CITY OF ALBUQUERQUE

Re: Arrive Hotel
717 Central Ave NW
Traffic Circulation Layout
Architect's Stamp XX-XX-XX (K14-D022)

Based upon the information provided in your submittal 05-01-2020, the above referenced plan cannot be approved for Building Permit until the following comments are addressed:

Traffic Circulation
Layout Basement

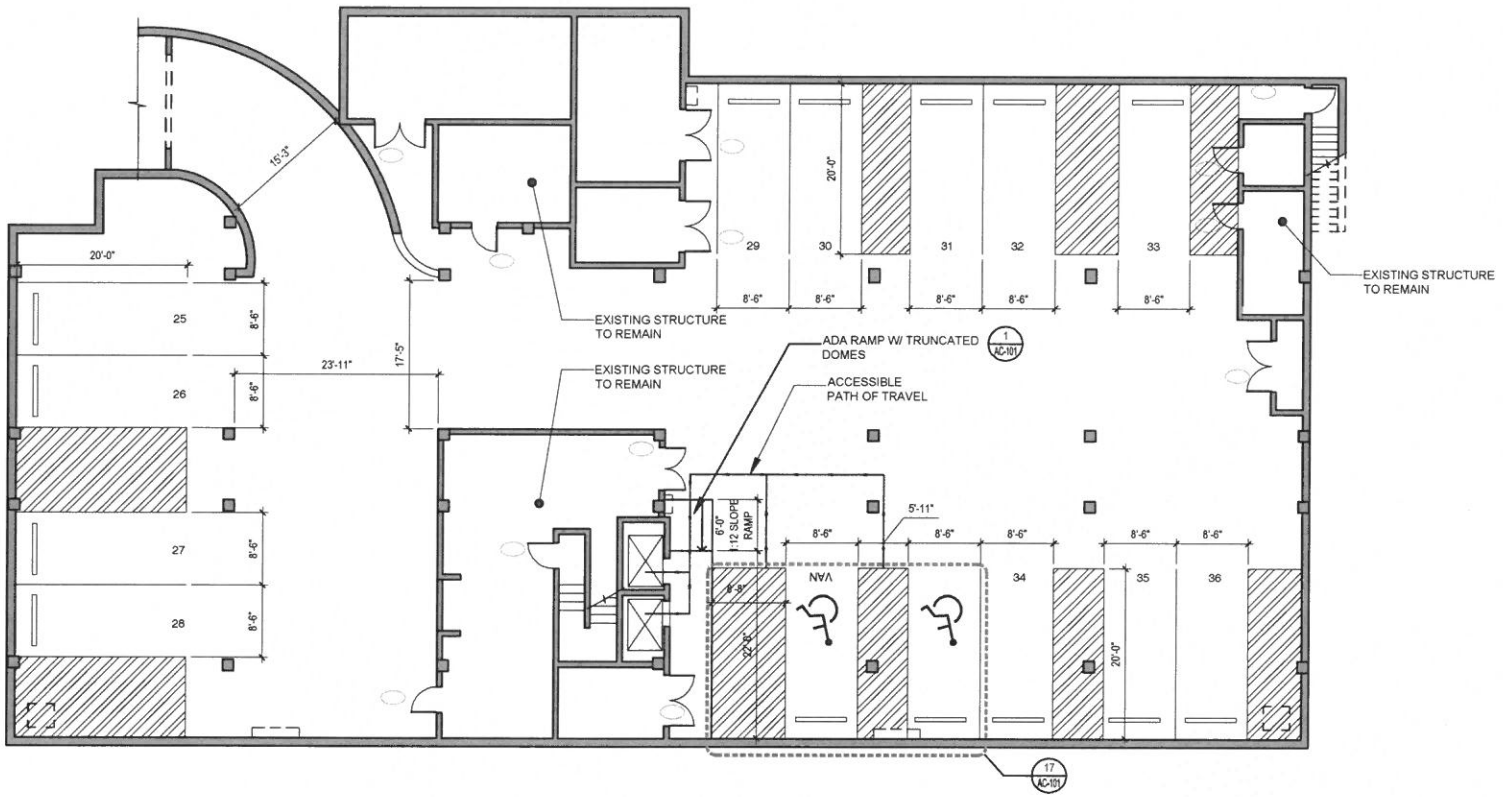
1. All submitted TCL sheets need to be stamped by Registered Architect and dated.
2. The sheet title should read Traffic Circulation Layout and not Traffic Control Layout.

3. Please coordinate all parking calculations with Zoning and list the number of parking spaces required by the zoning as well as the proposed number of parking spaces including bicycle and motorcycle parking.

6. Please identify all existing buildings, doors, structures, sidewalks, curbs, drive pads, wall and anything that influences the parking and circulation on the site.

7. Identify all existing access easements and rights of way width dimensions **(If applicable)**.
8. Identify the right of way width, medians, curb cuts, and street widths on Copper Avenue, Eight Street, and Central Avenue.

24. Show all drive aisle widths and radii. Some dimensions are not shown.
25. The minimum drive aisle dimensions are shown below

26. List radii for all curves shown; for passenger vehicles. Radius for delivery trucks, **fire trucks, etc. is 25 ft. or larger.**
27. Per the IDO, a 6 ft. wide ADA accessible pedestrian pathway is required from the public sidewalk to the building entrances. Please clearly show this pathway and provide details.
28. Per DPM, a 6 ft. wide ADA accessible pedestrian pathway is required from the ADA parking stall access aisles to the building entrances. Please clearly show this pathway (stripe path from parking aisle across drive aisle to entrance and provide details).
29. ADA accessible pedestrian pathway should not be placed behind parking space or adjacent to a vehicular way. Vehicle and pedestrian/wheel chair conflicts should be avoided as much as possible.

17 Accessible Parking Stall Details

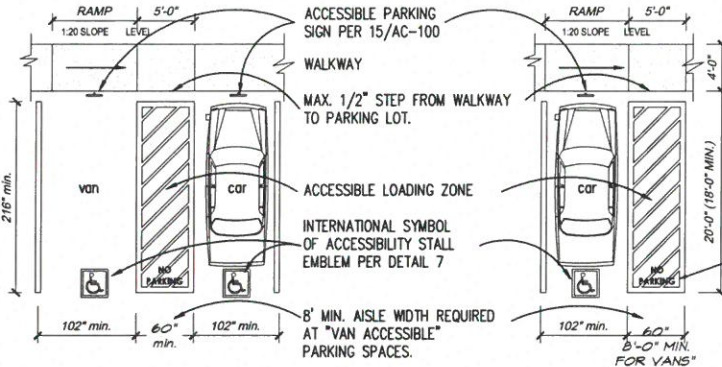
14. What is the angle of the proposed parking stall and does the dimensions following the DPM requirements?
15. The ADA accessible spaces must include an access aisle. Van accessible aisles should be 8ft wide; all others should be 5ft wide. Provide parking bumpers since min. overhang of vehicles is 2ft (angle parking stalls).
16. The ADA accessible parking sign must have the required language per 66-7-352.4C NMSA 1978 **"Violators Are Subject to a Fine and/or Towing."** Please call out detail and location of signs.
17. The ADA access aisles shall have the words **"NO PARKING"** in capital letters, each of which shall be at least one foot high and at least two inches wide, placed at the rear of the parking space so as to be close to where an adjacent vehicle's rear tire would be placed. (66-1-4.1.B NMSA 1978)

1 Accessible Ramps

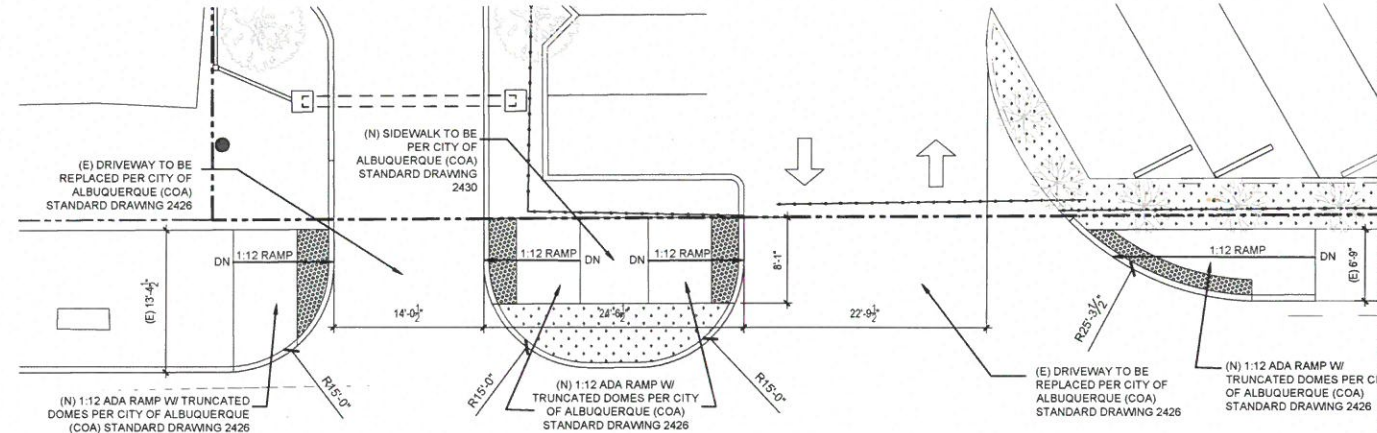
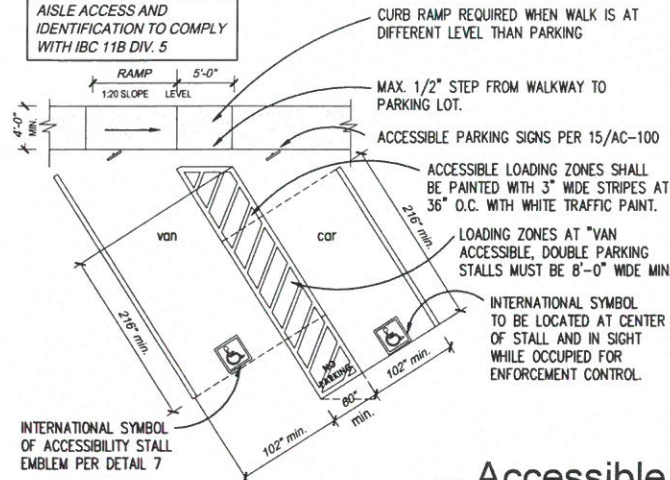
18. **ADA curb ramps must be updated to current standards and have truncated domes installed within COA right-of-way.**
19. Motorcycle parking spaces shall be designated by its own conspicuously posted upright sign, either free-standing or wall mounted per the zoning code.

3 DRIVE PAD DETAIL

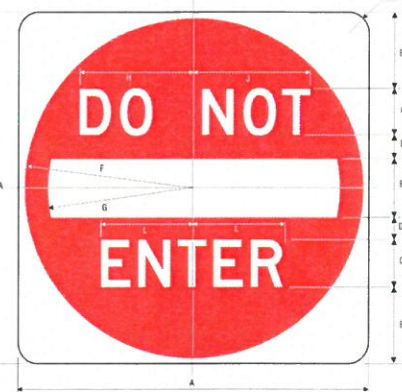
4. Provide build notes for all infrastructure within City right-of-way that will need to be replaced to current and updated City of Albuquerque standards which includes any broken/cracked/ damaged curb&gutter, sidewalk, driveways, driveways with valley and wheel ramps and either reference City of Albuquerque (COA) std dwg and/or provide details.
